**Consultation Response from KC,  
Trees**

**2020/94184 Stonecroft, Daisy Lea Lane, Lindley, Huddersfield, HD3 3LL**

**Erection of car port (Within a Conservation Area)**

**Date Responded: 04/02/21**

Daisy Lea Lane

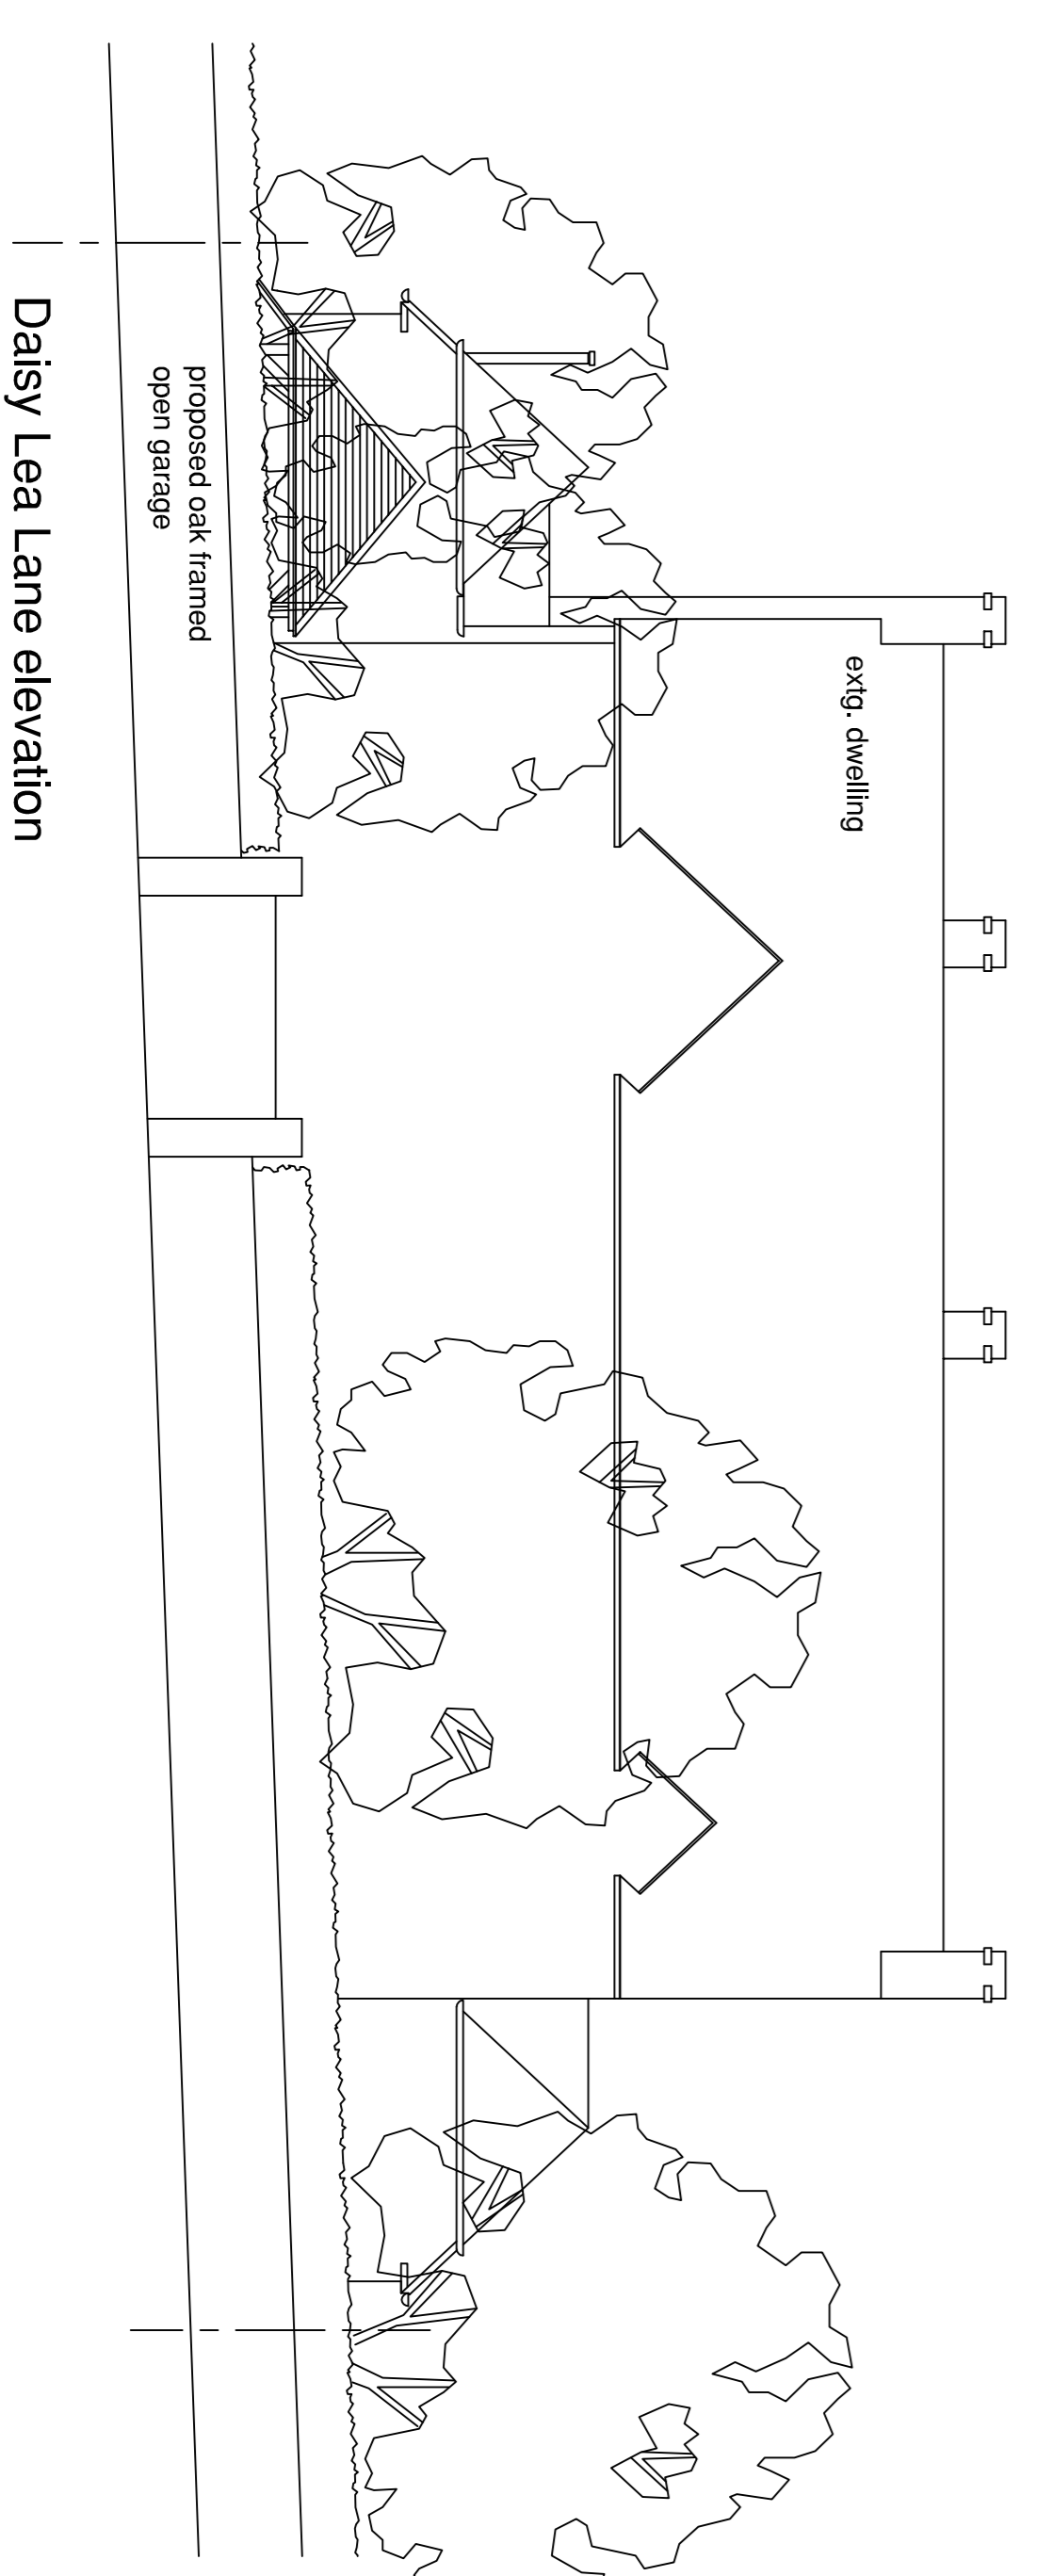
The property is within the Edgerton Conservation Area which protects all trees above a diameter of 75mm, when measured at 1.5m above ground level. The proposed car port would have only minimal impact on the roots of the adjacent laburnum trees and require the removal of garden shrubs of little consequence to the character of the conservation area. I would therefore have no objection to the proposals.
